Our Ref: DOC18/276144

RE: Concept Development Application (Staged Development) for alterations and additions to the Intercontinental Hotel and Transport House – Response to Submissions (SSD 7693)

Rajeev Maini
Acting Director, Heritage Operations
Heritage Division
Office of Environment and Heritage
AS A DELEGATE OF NSW HERITAGE COUNCIL
24 May 2018

SETBACK DIAGRAM | VIEW FROM NORTH-EAST

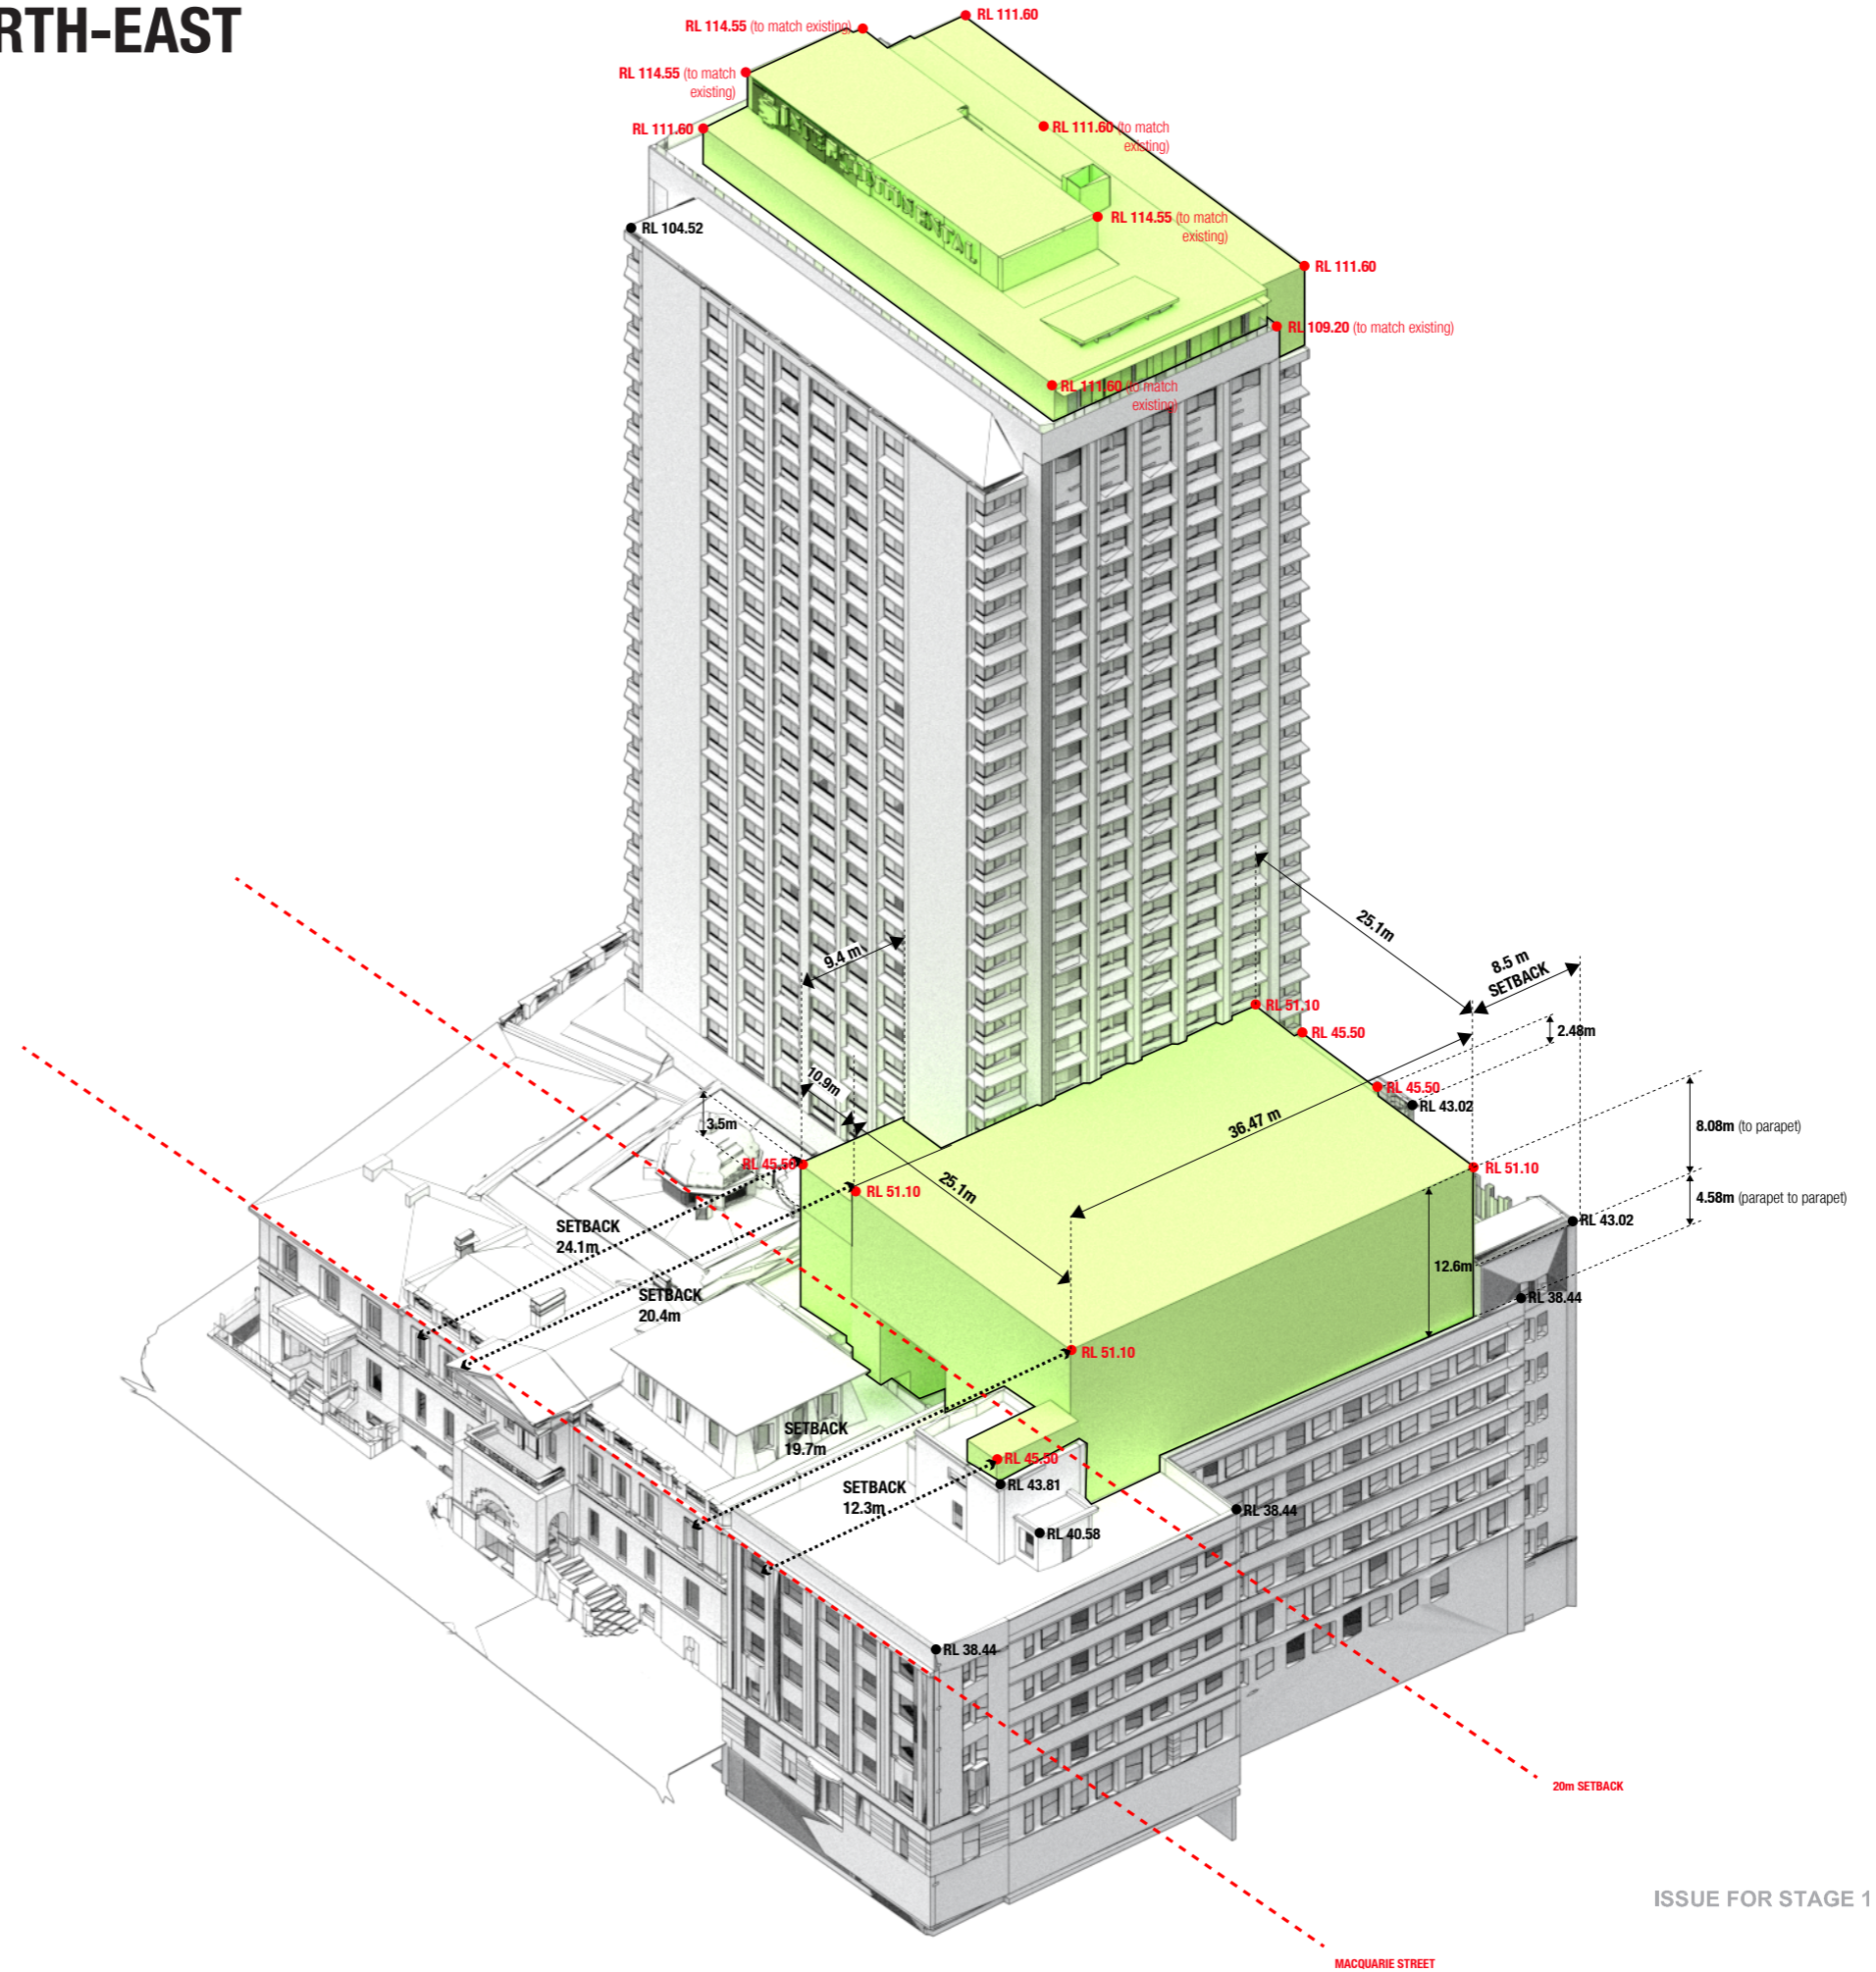
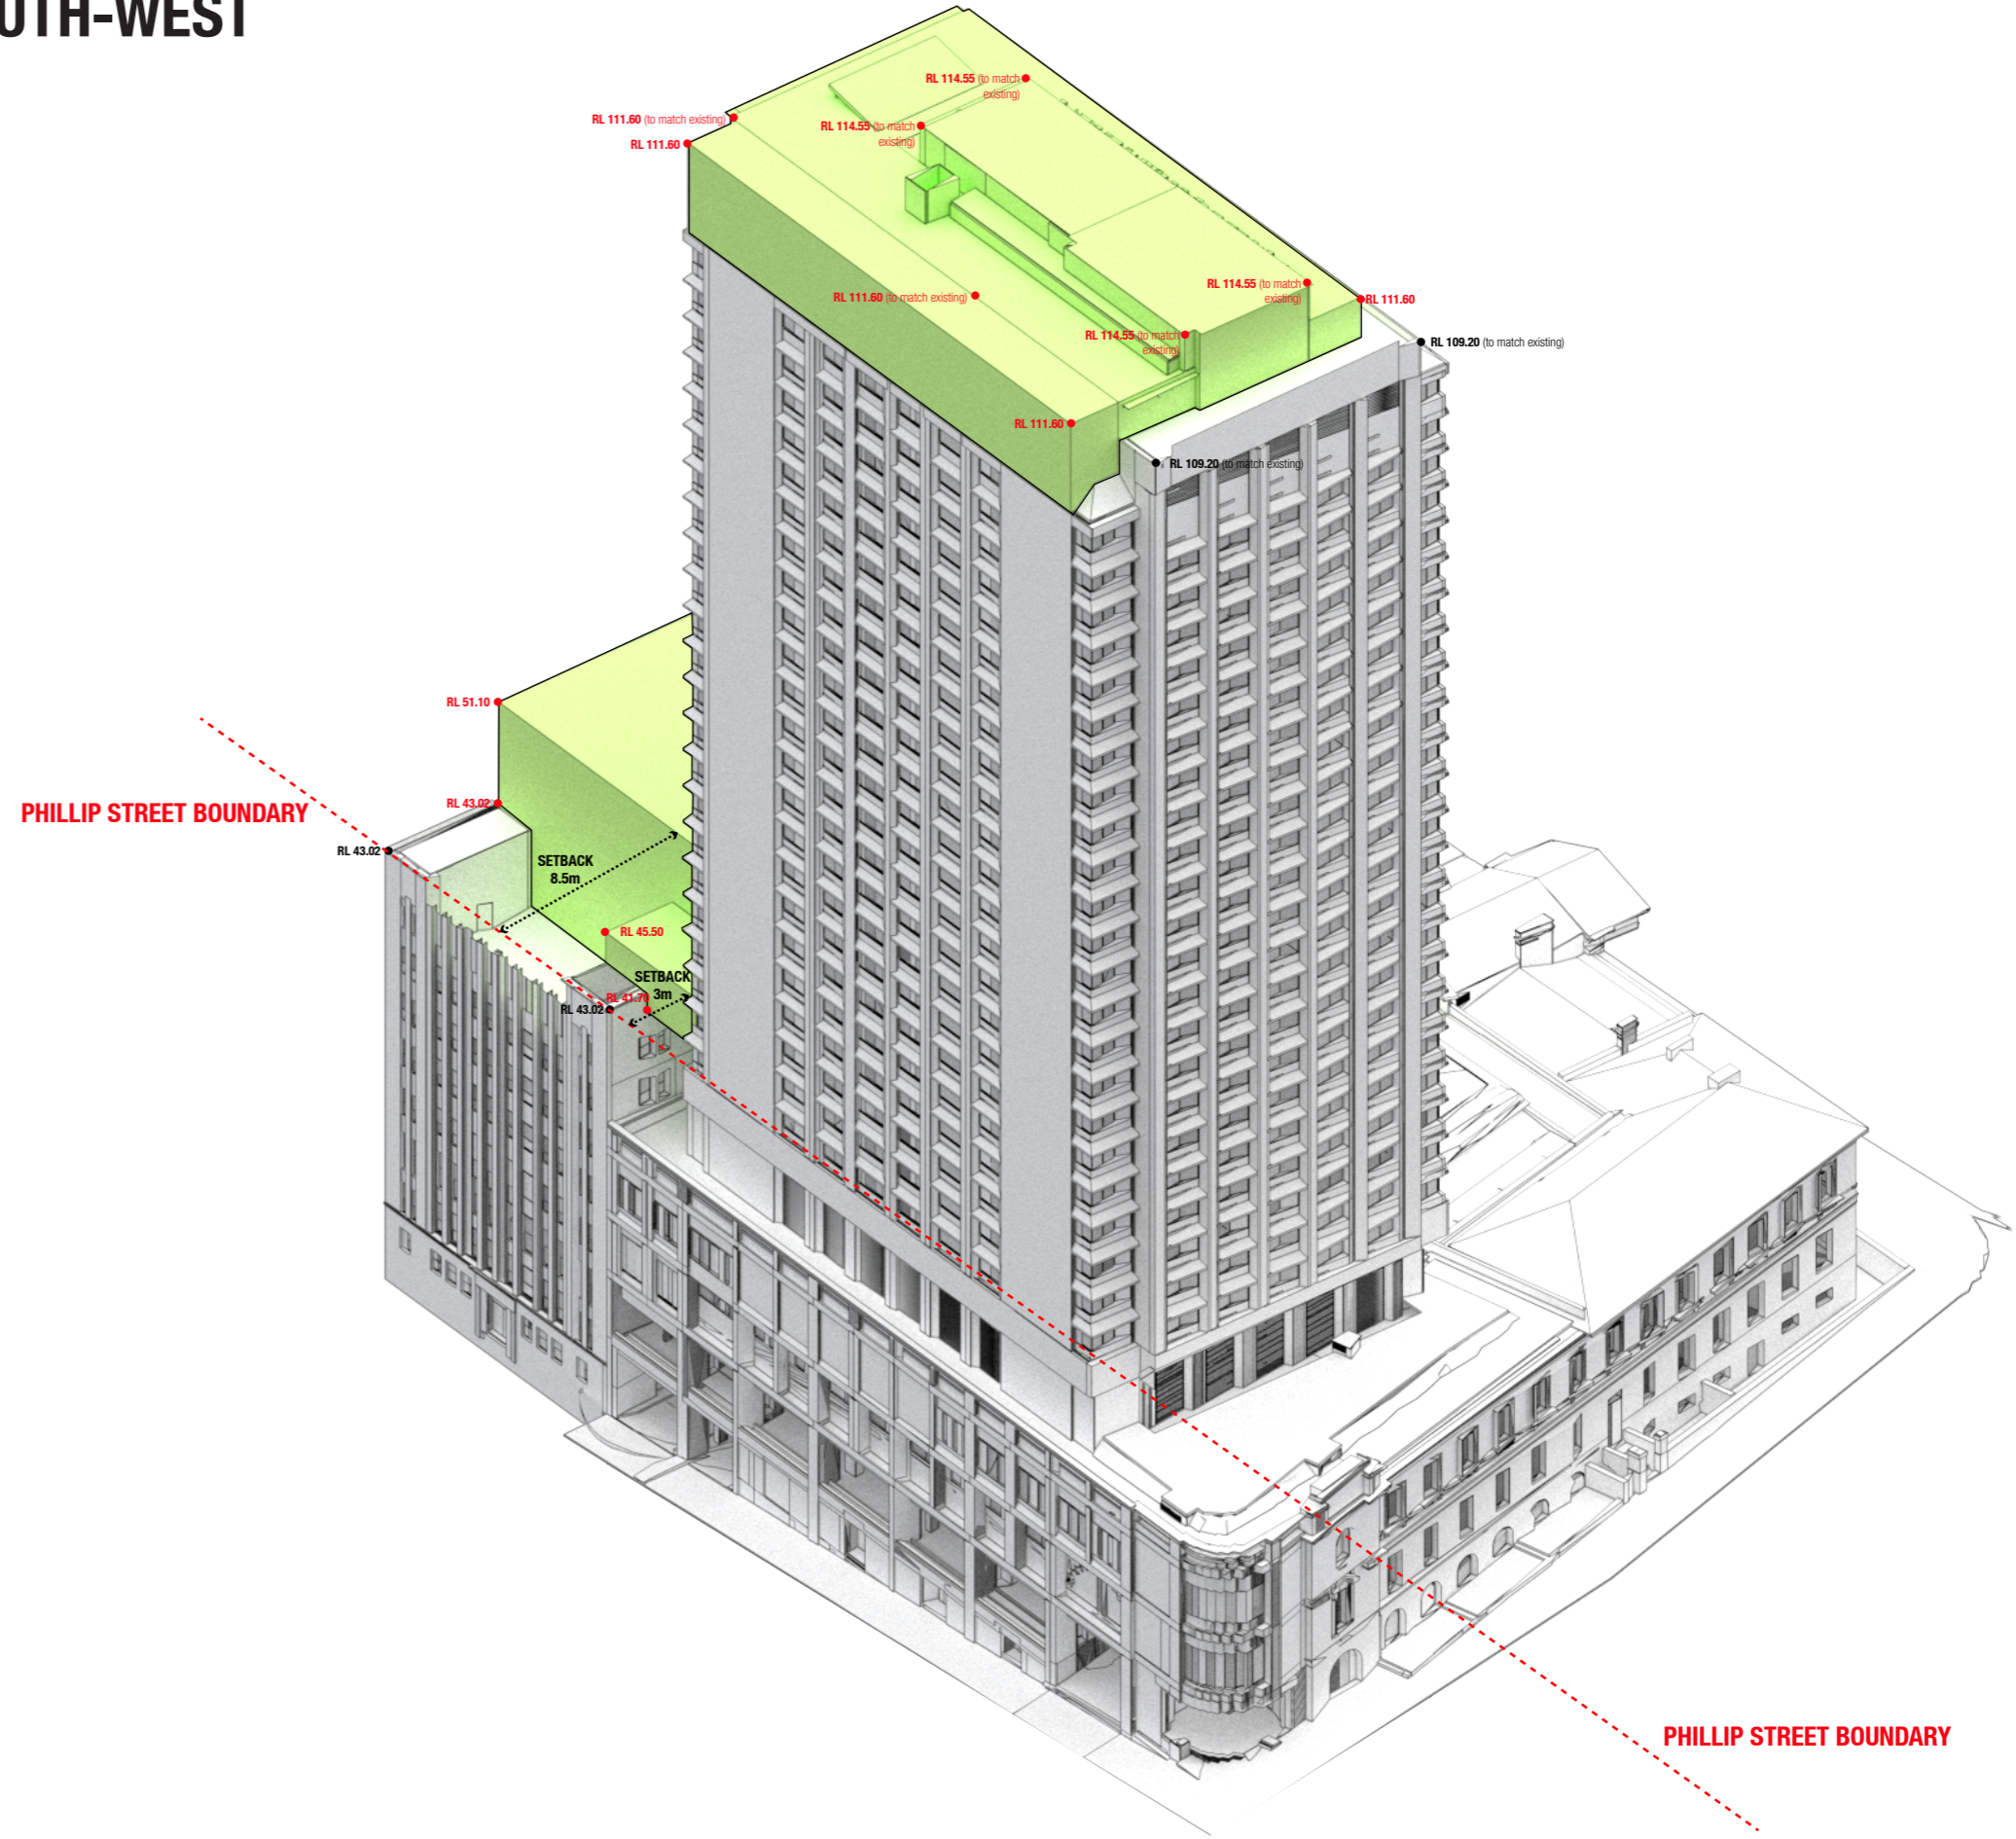
It is, however, noted that the bulk of proposed rooftop addition behind the 1890s Treasury Building northern wing extension (Strong Room Building and Link Building) remains unchanged in the revised proposal. These additions would have a major adverse impact on significant views to the site (as identified in the Draft CMP) from several State Heritage items in the vicinity including Royal Botanic Gardens, the Sydney Conservatorium of Music and First Government House Site. Furthermore, these additions would not meet the SDCP 2012 minimum upper setback requirements from the Macquarie Street frontage of 30m and would encroach onto the existing setback between the later 1980s hotel development and 1890s Treasury Building northern wing extension, also impacting on the northern view above from the cortile spaces and the former Treasury Building Atrium.

It is, therefore, reiterated that the scale and bulk of the above noted rooftop addition be reconsidered and reduced to minimise visual impacts. These additions should be amended to comply with the SDCP 2012 setback requirements from Macquarie Street frontage to protect the heritage values and setting of the Treasury Buildings and the Macquarie Streetscape within the low-scale historic precinct.
